Our ref: Q230249
Your ref: 20/04145/FU
Email: sean.rawling@quod.com
Date: 22 November 2023

Town and Country Planning Act 1980 (as amended)
Section 96a and Section 73 Applications Pursuant to Planning Permission
Reference 20/04145/FU
Foundry Street / Saxton Lane Former, Leeds

Please find enclosed a Section 96a (S96a) and Section 73 (S73) application on behalf of Wakefield and District Housing Ltd (the “Applicant”) pursuant to planning permission 20/04145/FU (the “Consent”) at Foundry Street / Saxton Lane, Leeds (the “Site”).

- **Section 96a:** seeks non-materials amendments to the elevations and an extension of the stair core at from levels 17 to 19.
- **Section 73:** seeks consent for an additional three affordable units in place of the first floor amenity space.

DWG NO	REV
48514-BBA-03-17-DR-A-0318	C01

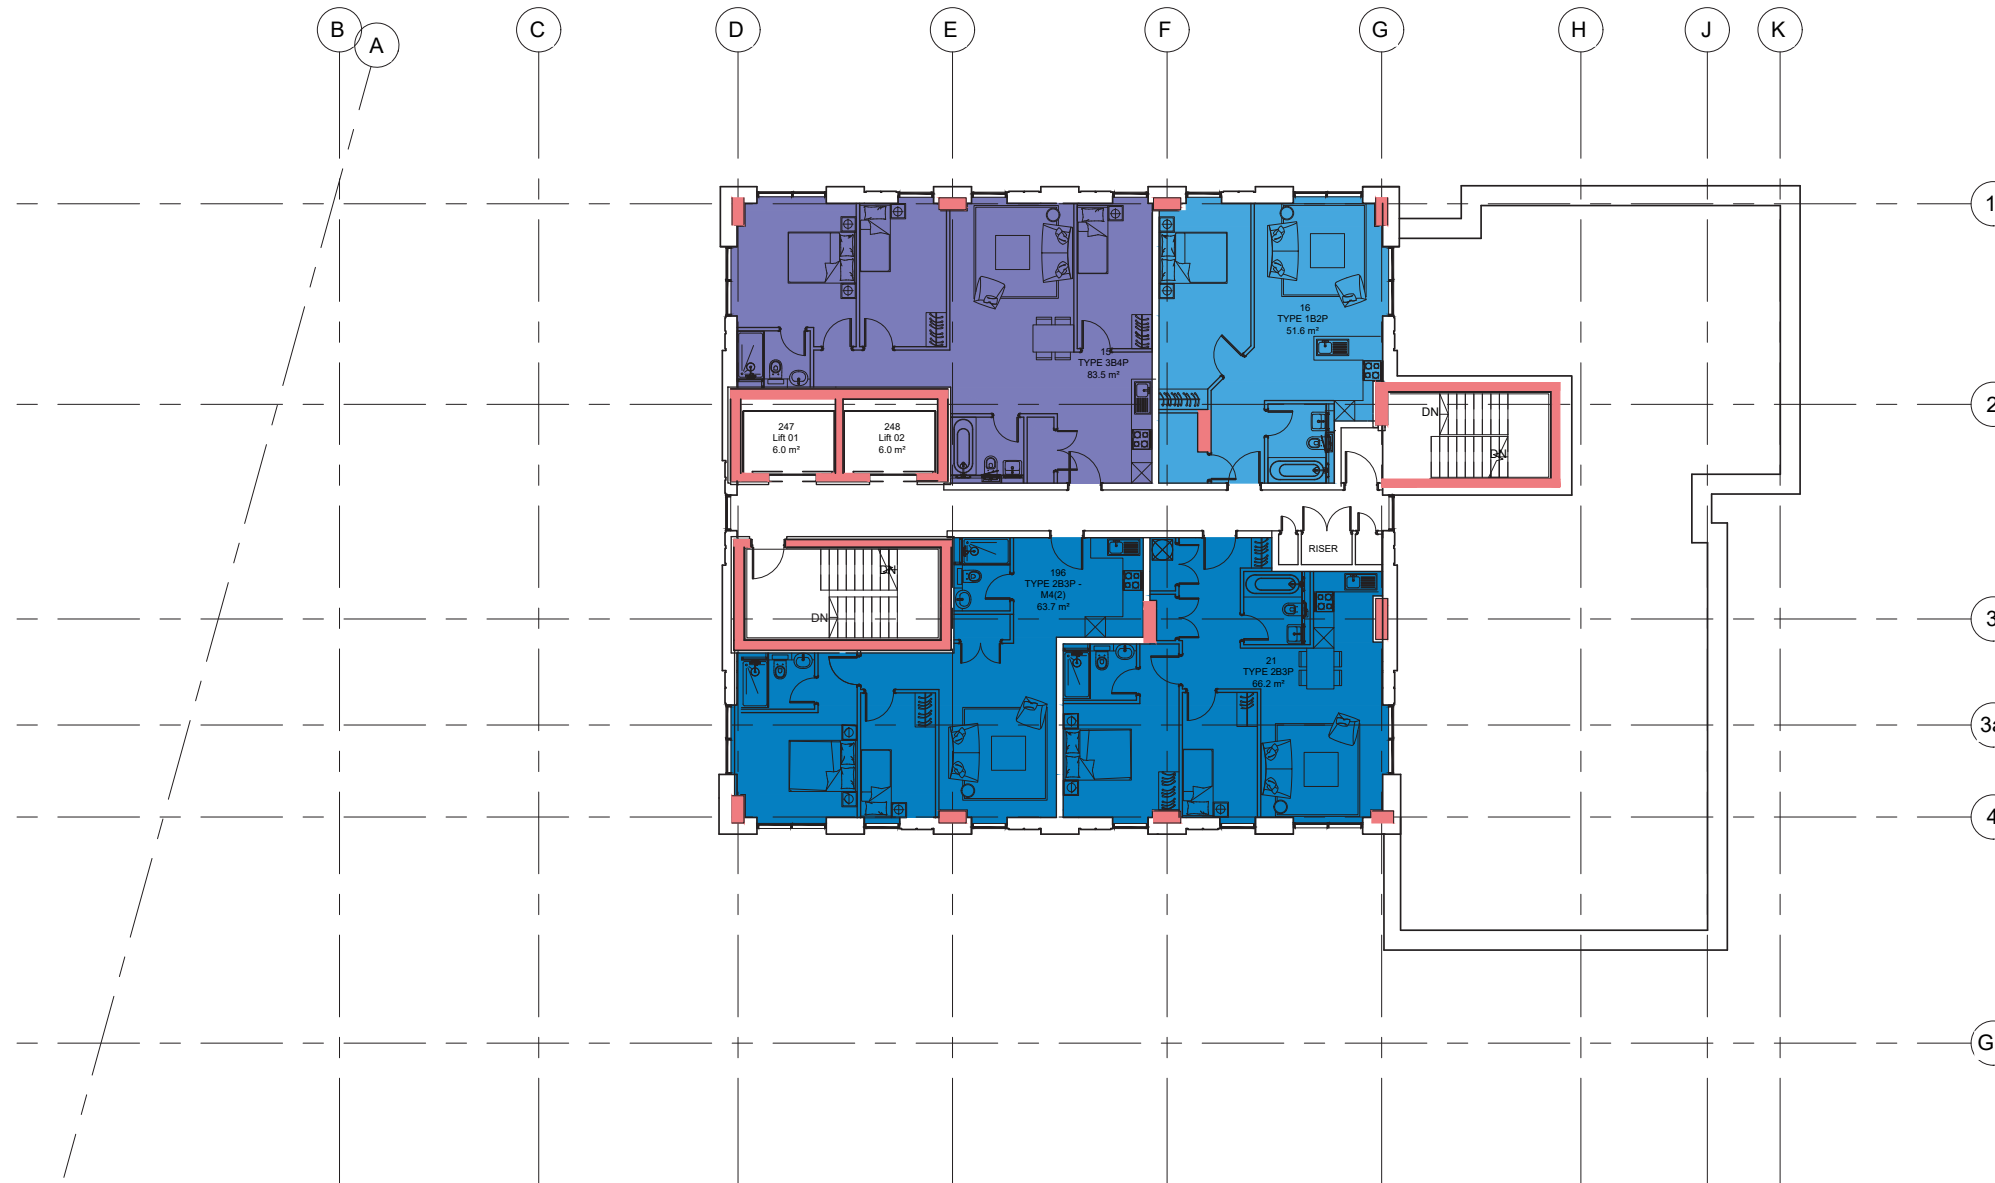
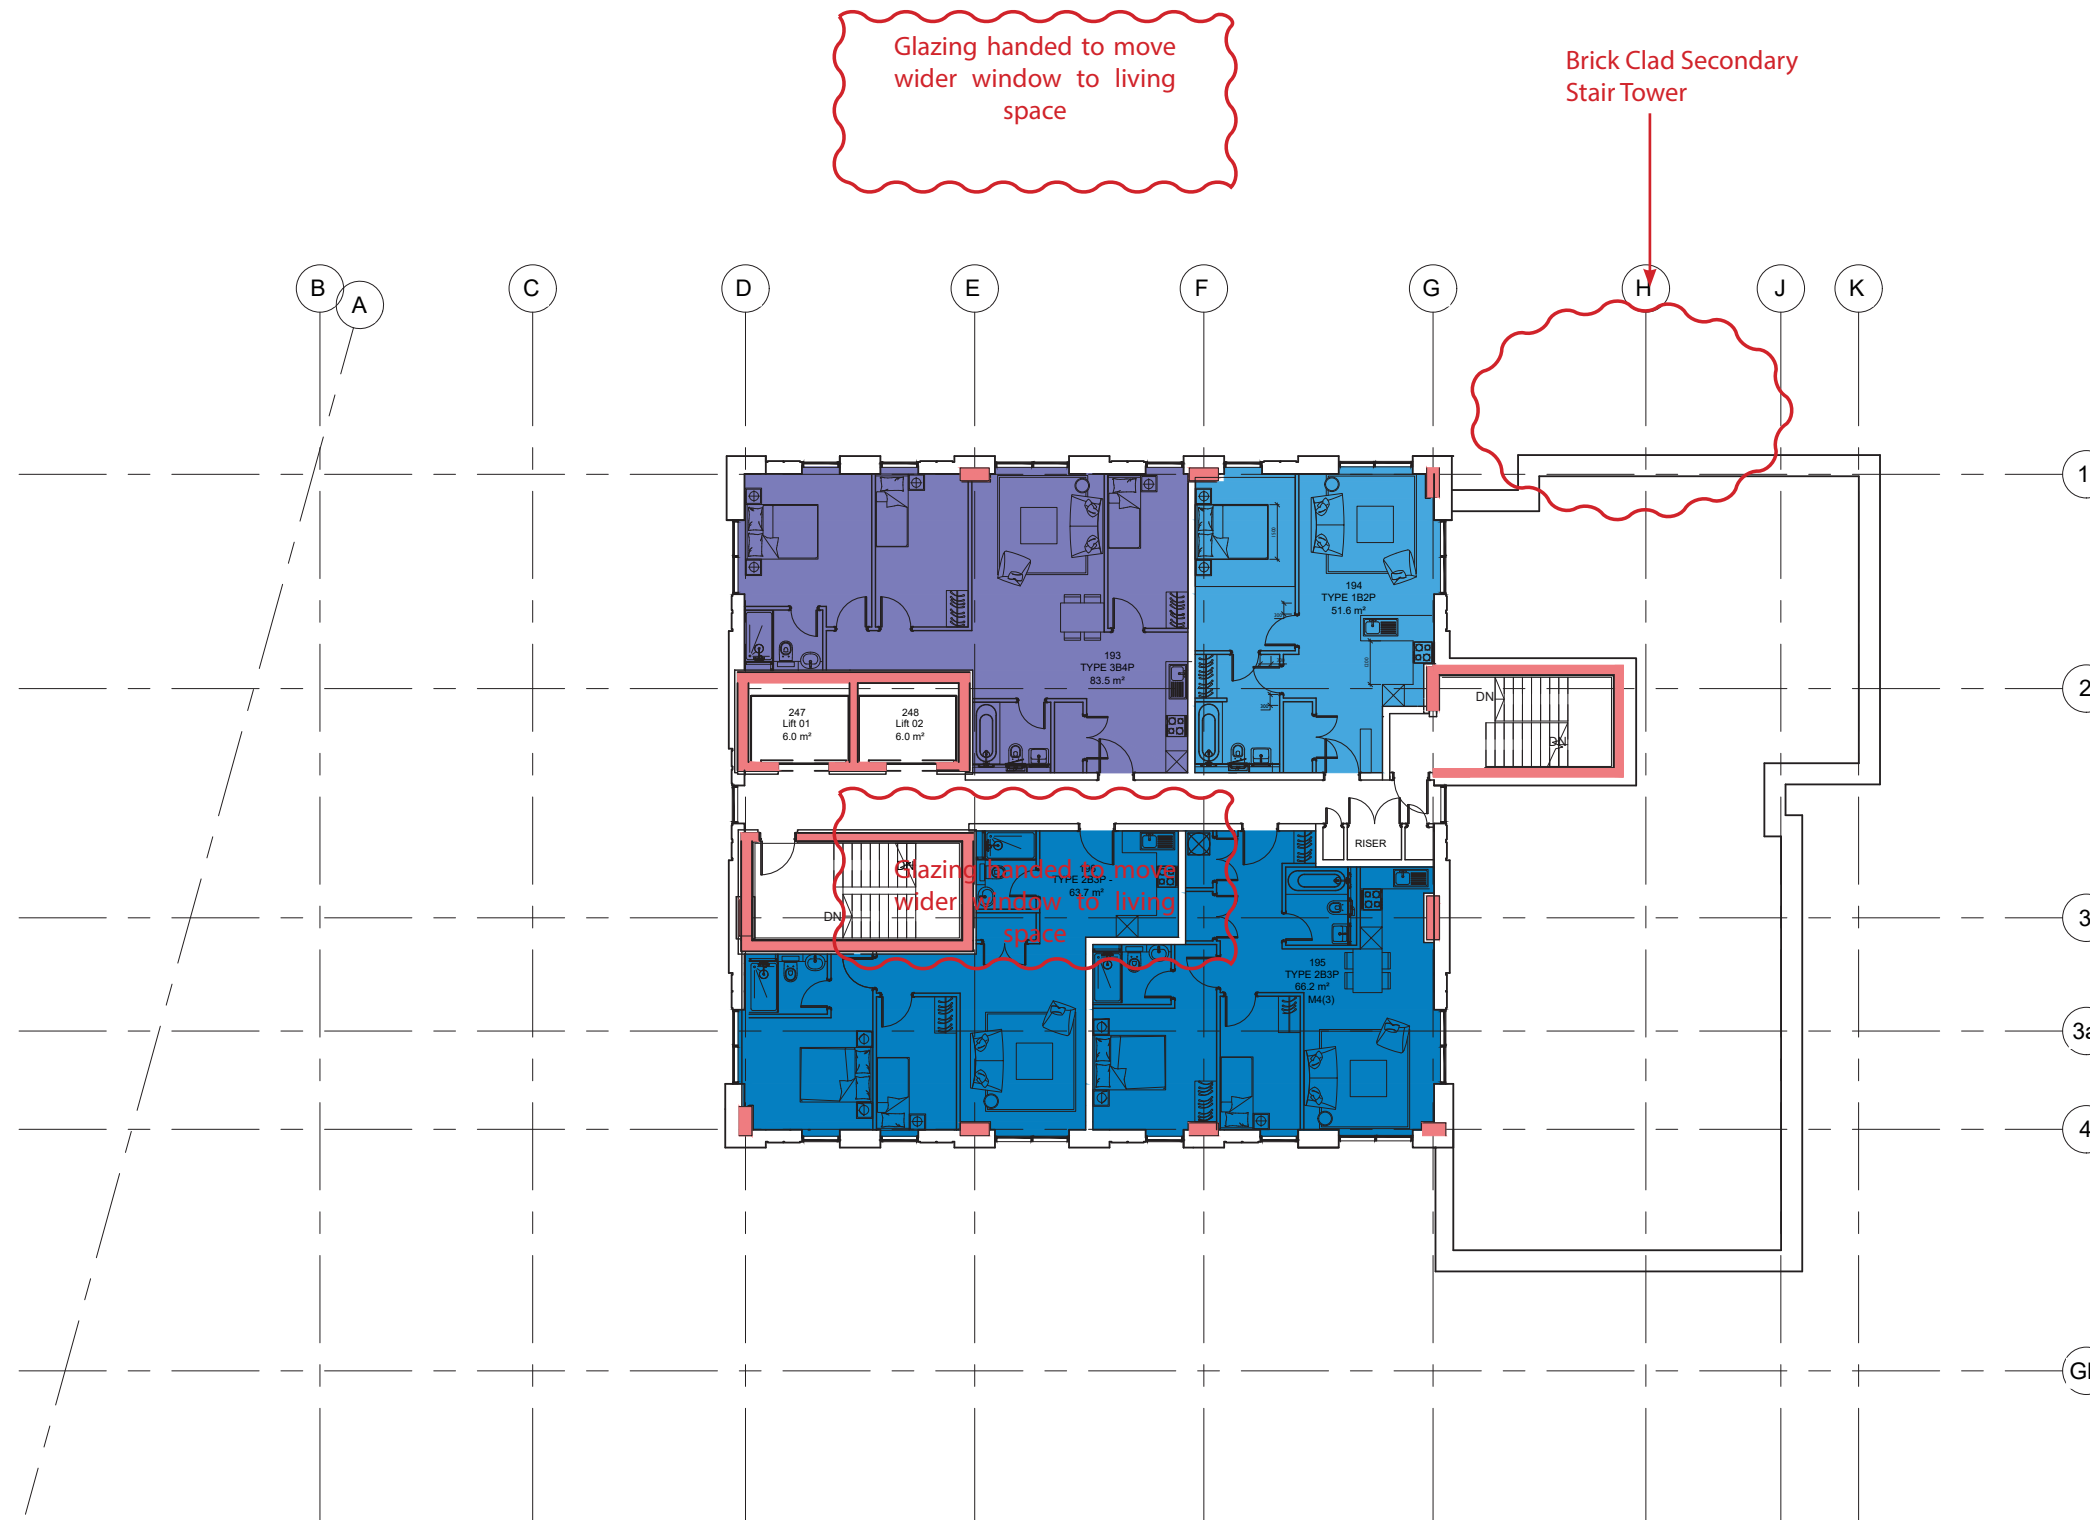
The previous S96a application consented a second stair core from ground floor level up to level 16. This S96a application seeks to extend the stair core from levels 17 to 19, to serve the four dwellings per floor. Due to the stepped nature of the existing building, this will result in a small extension to the massing at levels 17-19 only.

The extension of the second stair core from levels 17 to 19 will further improve the development in terms of fire safety to these top floors. Indeed, this is now a requirement for tall buildings, such as the site, to provide for a second stair core. This will ensure that access for fire fighters and for escape for residents to these top levels if limited to a single stair core, which could become obstructed. This provides an actual significant safety feature, whilst also providing residents with additional reassurance and safety.

This will result in an external change to the massing to accommodate the stair core only, however, this will be set back, thus will not be seen in any views from ground level.

The stair core will be 4.8m x 3.7m in width and length, and set back by 7m from the eastern elevation, 5.4m from the northern elevation and 10m from the southern elevation. The stair core will be 8.8m in height, sitting circa 1m lower than the maximum height of the building. As such, the stair core will not be seen in any short distance ground level views. Whilst the stair core may be seen from long distance

FOR THE
UNITED LIVING GROUP
- SAXTON HOUSE
Saxton Lane, Leeds
PROPOSED NORTH ELEVATION

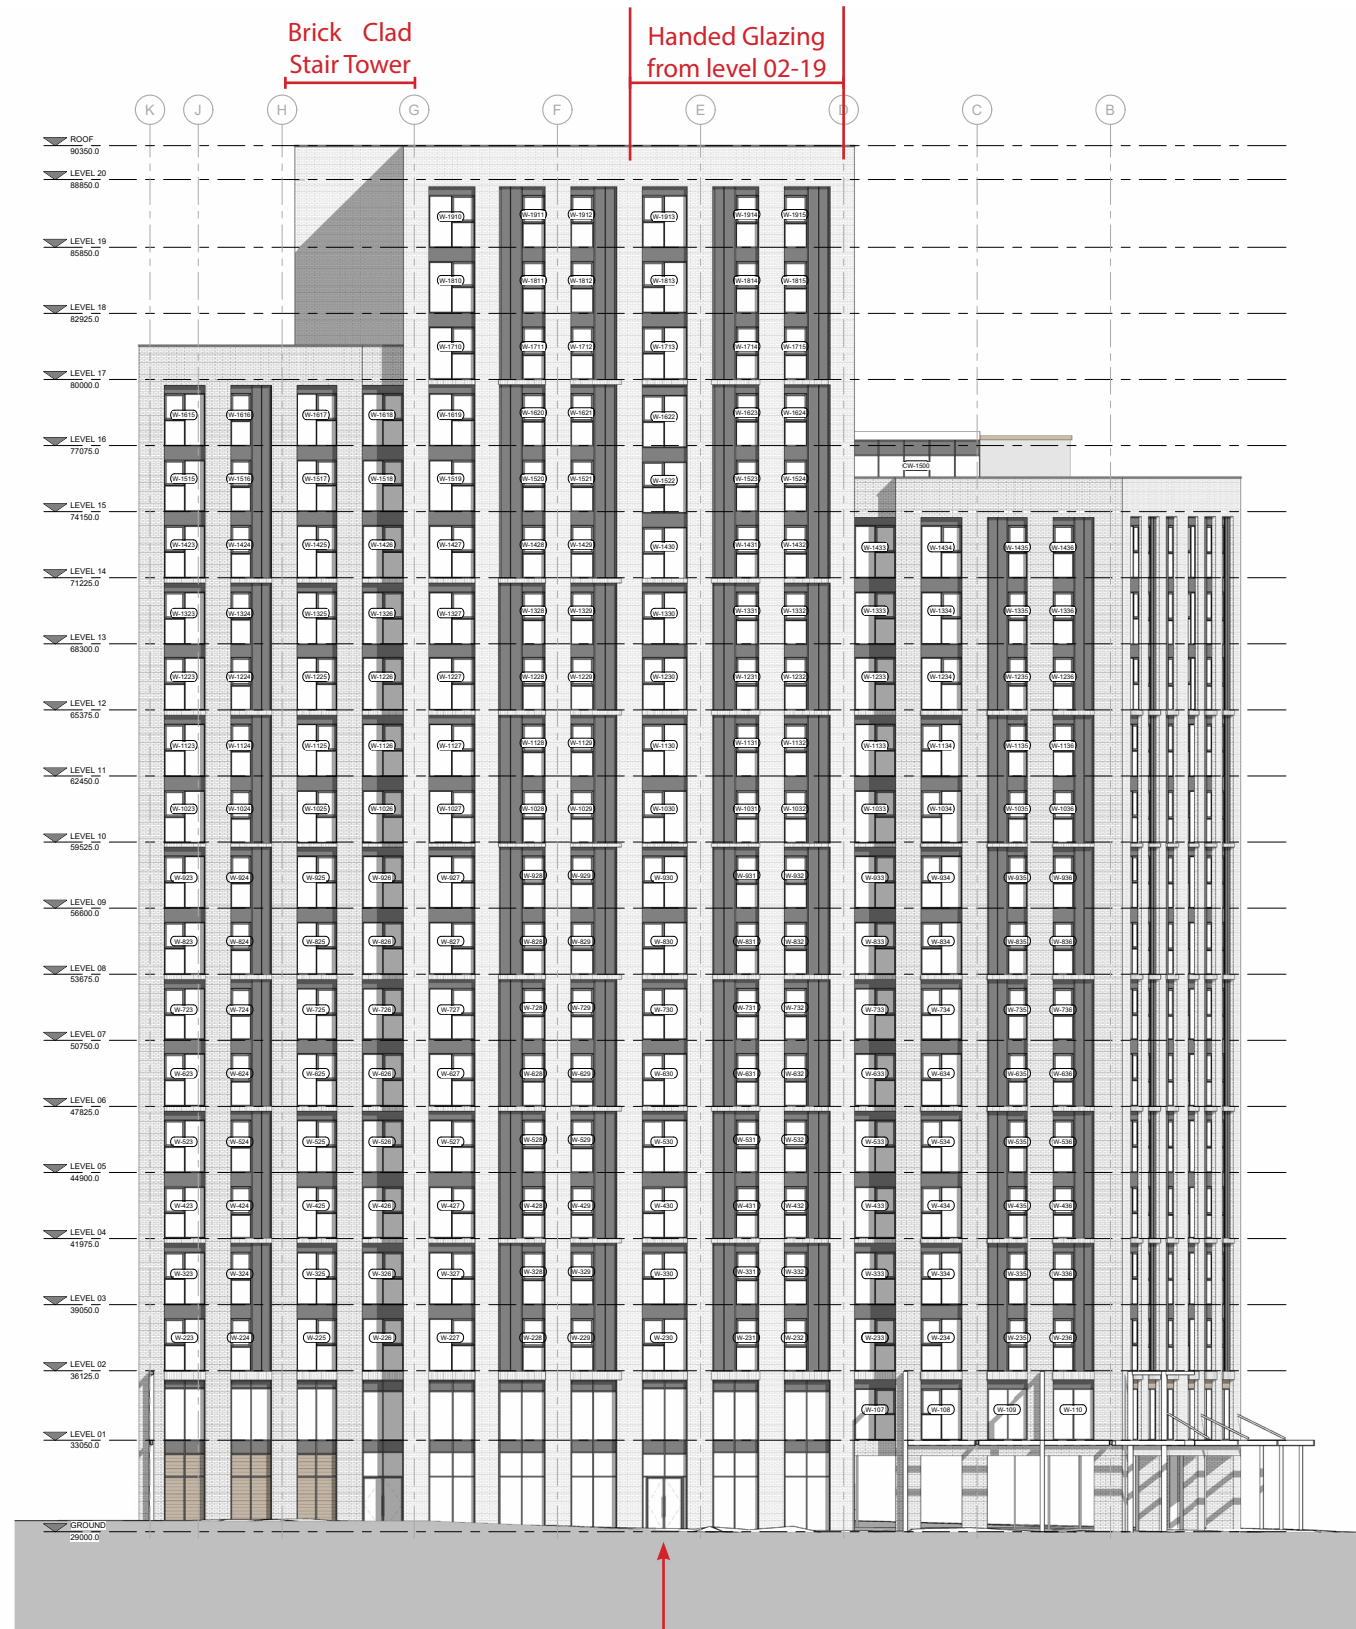
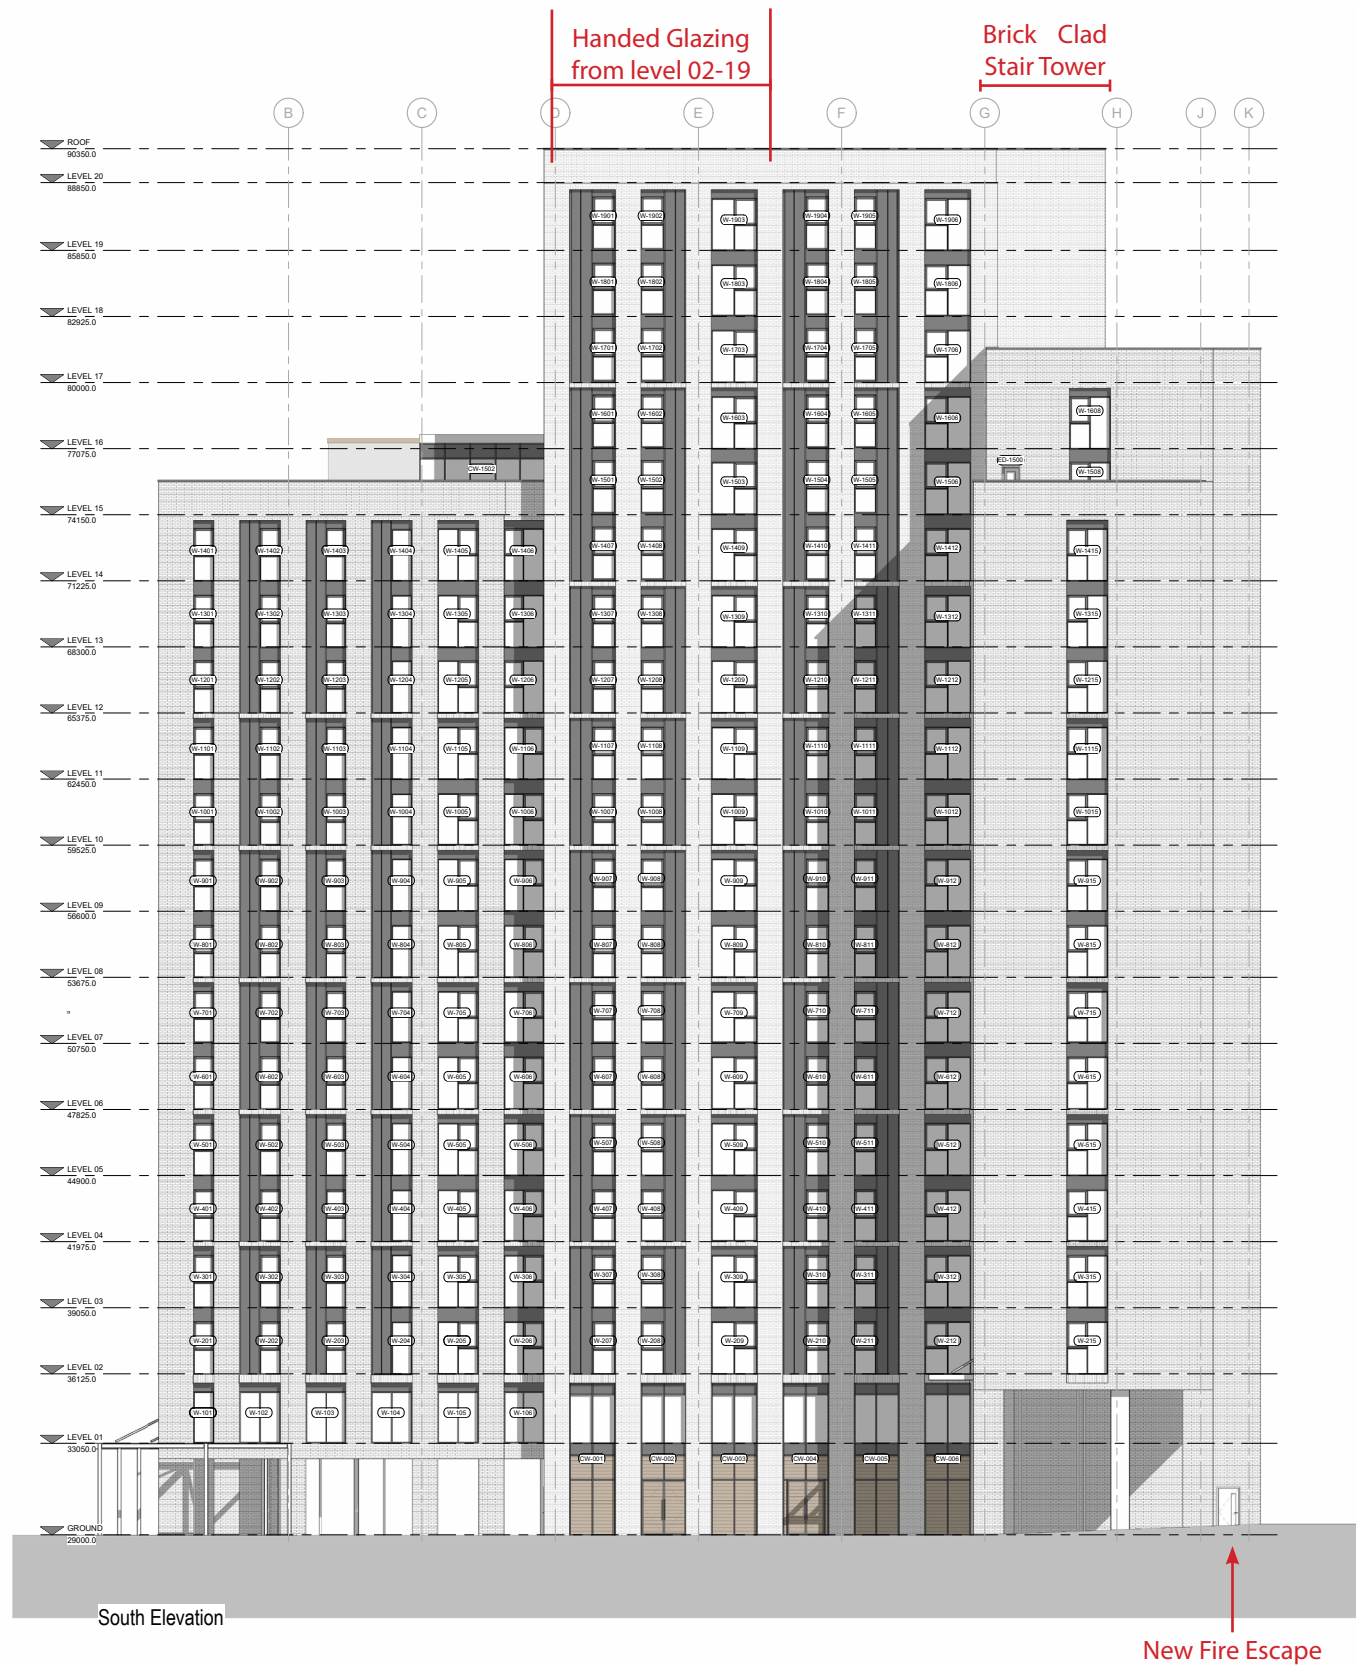
- Shift of proposed entrance.
- Extension of bike store to allow for 207 spaces.
- Additional fire escape door along eastern elevation for second stair core.
- Shift of windows between living space and bedroom to allow for wider window to living spaces at levels 2 to 19, along central spine of the northern and southern elevations.

In terms of design and appearance, the remaining external and internal alterations to the building are negligible. The change to the entrance door, inclusion of a new fire escape door, and shifting of the bedroom and living room windows have no discernible effect on the design and appearance of the proposals, particularly when considered in the context of the wider development.
